Gate Burton Issue Specific Hearing (ISH) 2 - Draft DCO

7000 Acres is an interested party in the DCO Examination for the Gate Burton Solar Project and three additional solar NSIPs in the local area.

FIGURE NUMBER
 Figure EN010131/APP/3.8

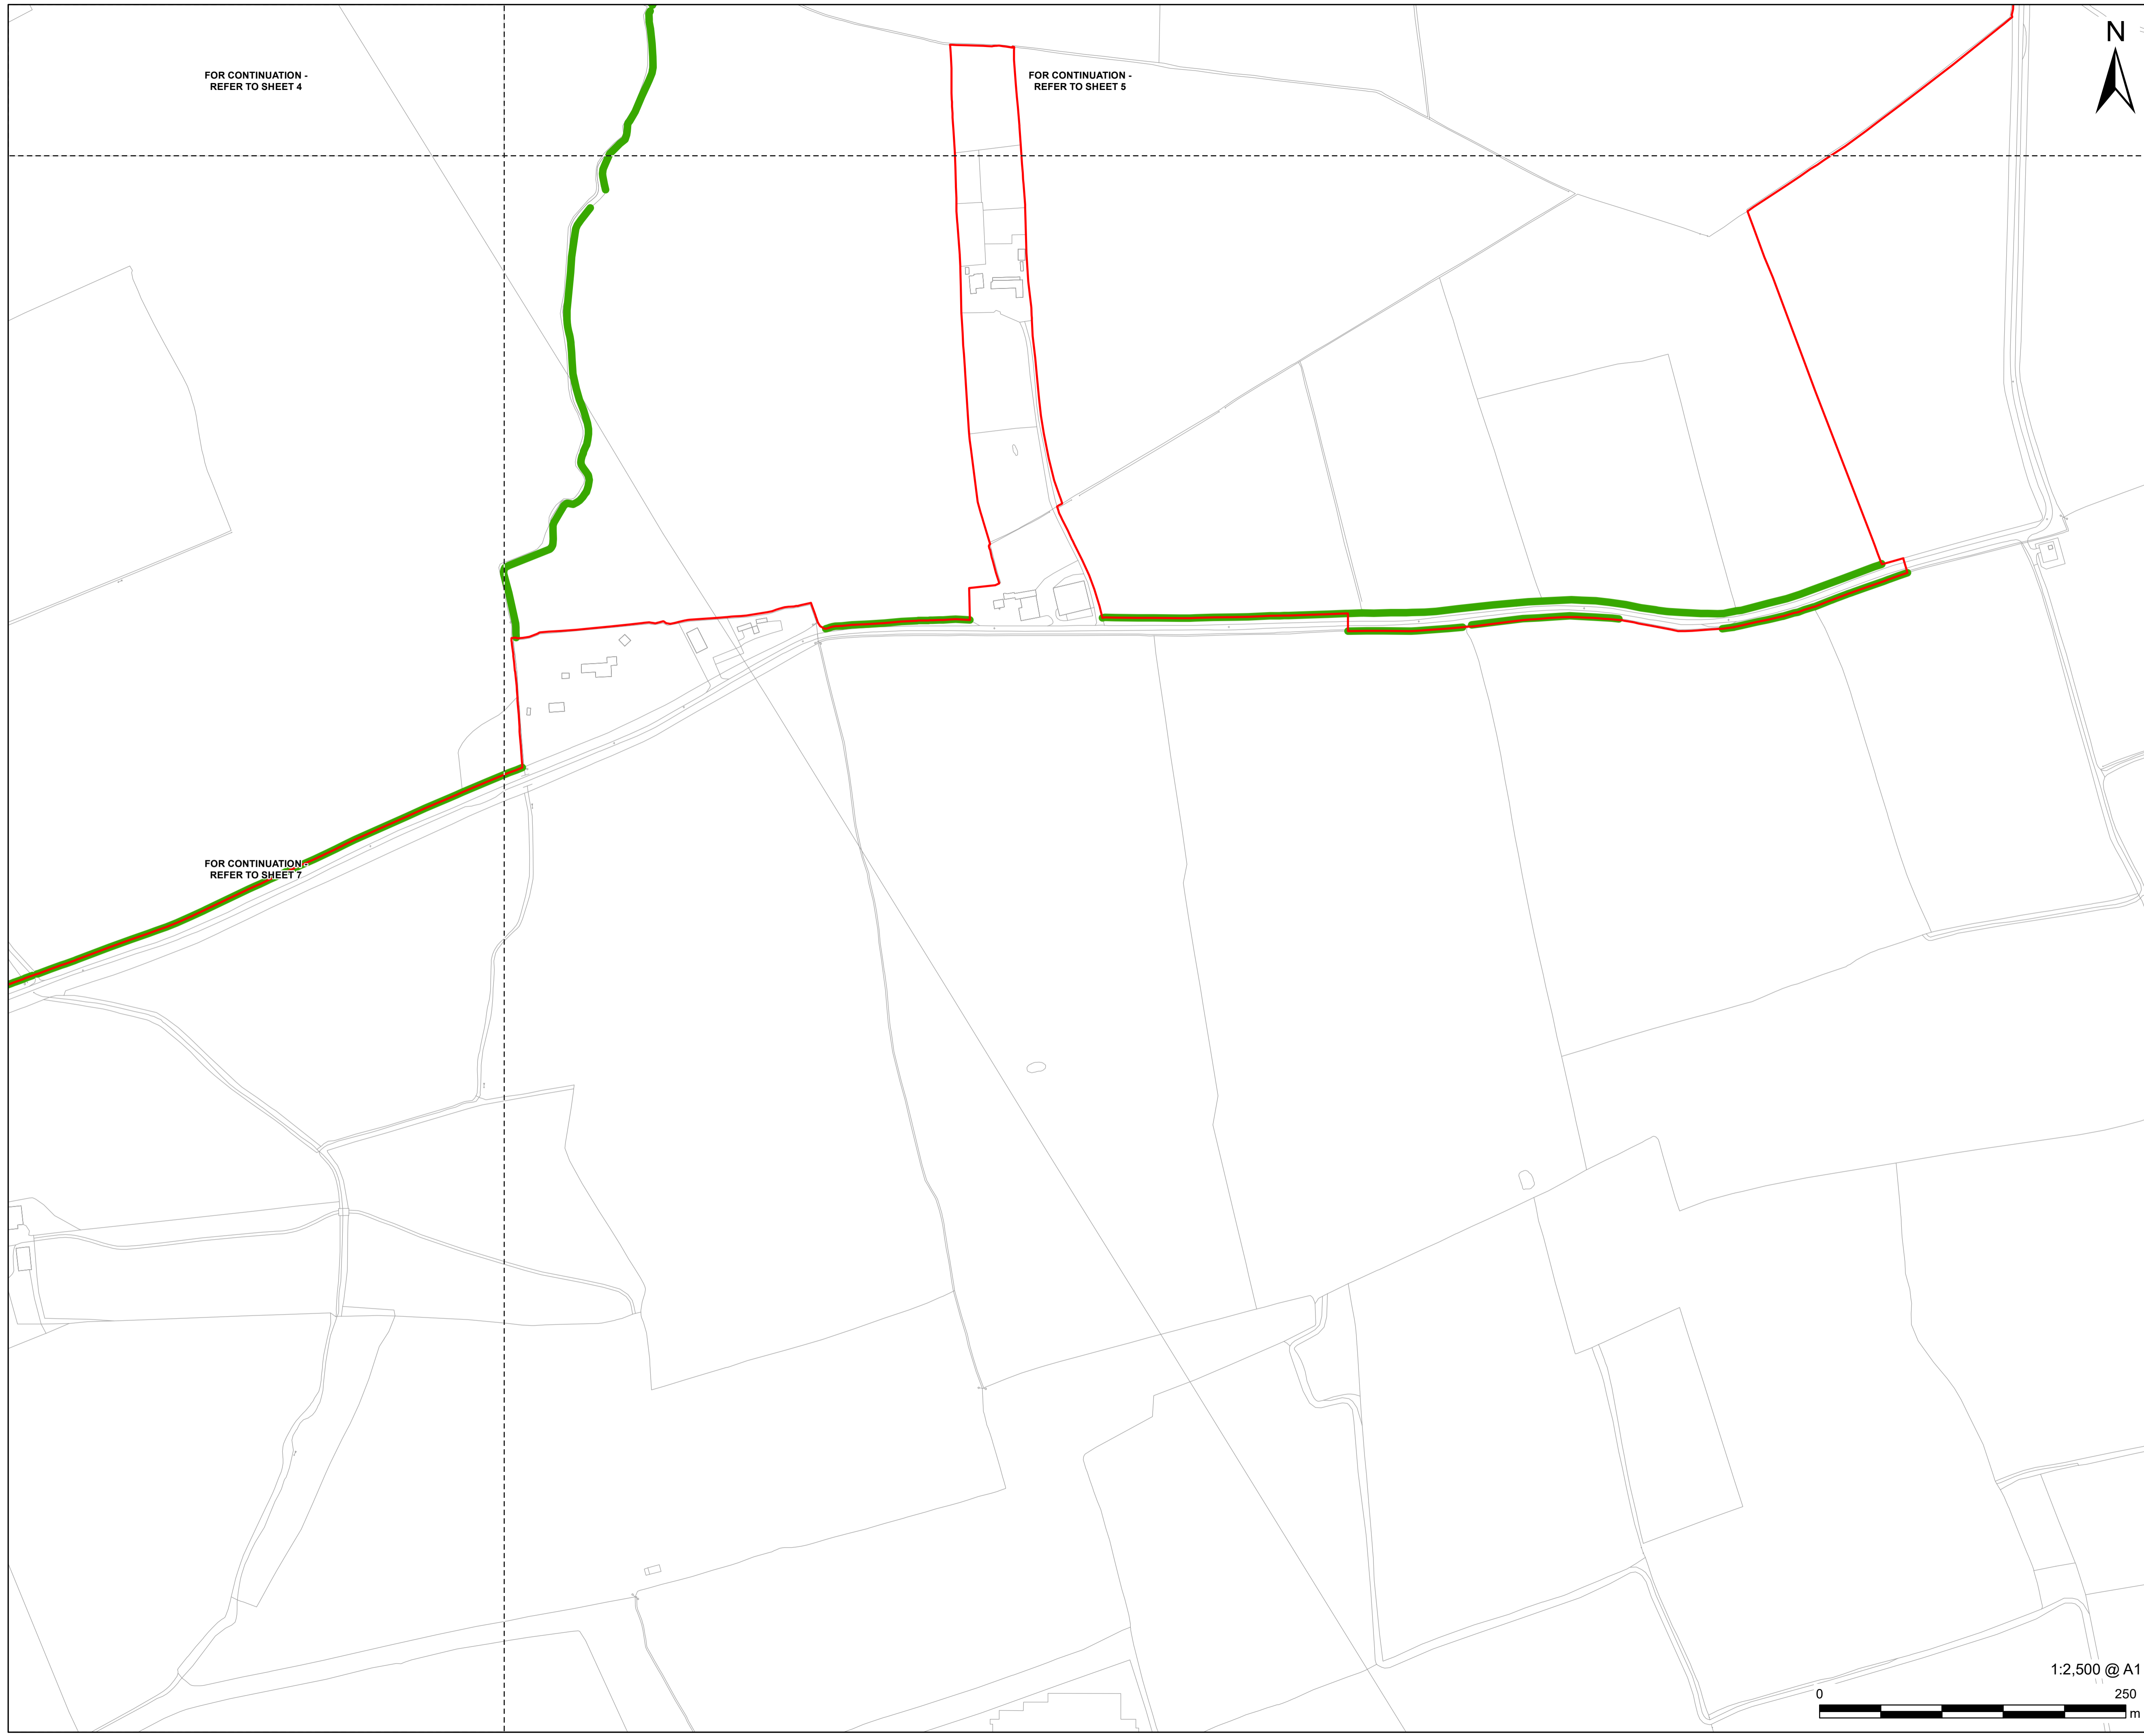
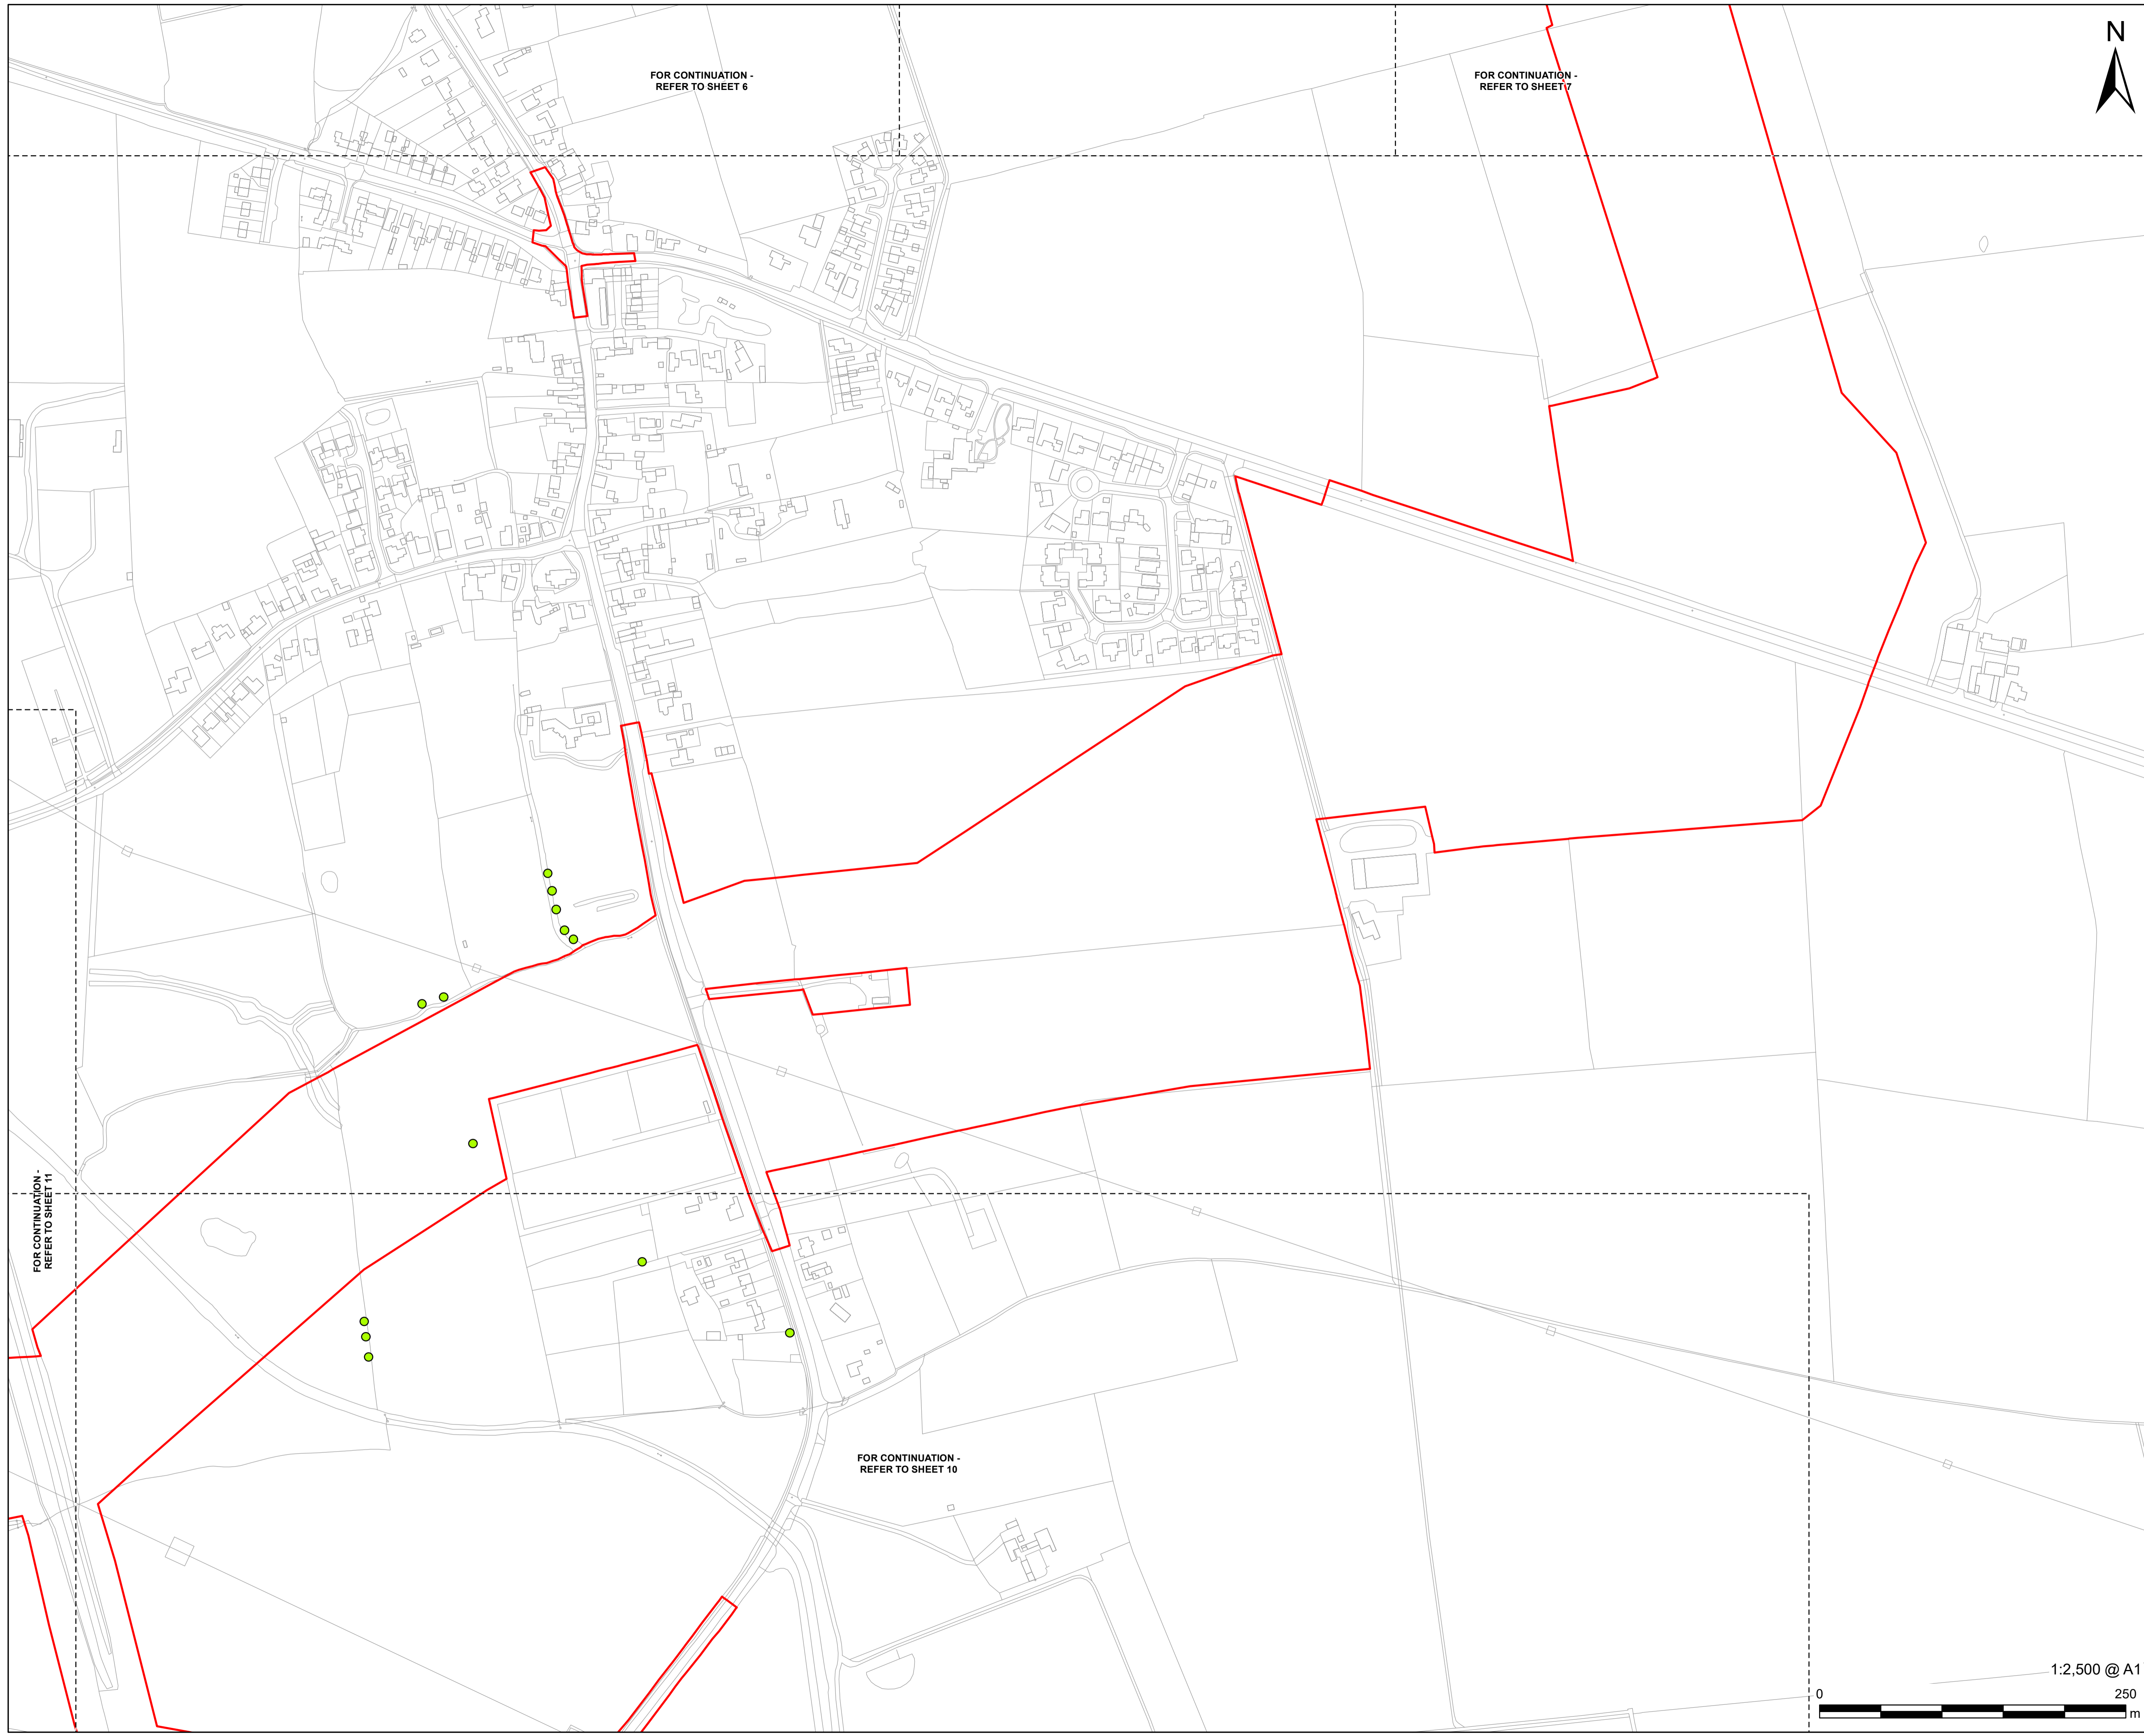
- The Applicant has failed to explain why in Requirements 38 and 39 they should have the ability to fell any tree or remove any hedge they wish. The current wording of the dDCO would allow the Applicant to remove all hedgerows and trees they believe to be necessary without any checks and balances. In the opinion of 7000 Acres, the dDCO should be revised to state that any lopping, pruning, felling or removal of hedgerows, trees or shrubs should be in accordance with the Landscape and Ecological Management Plan.
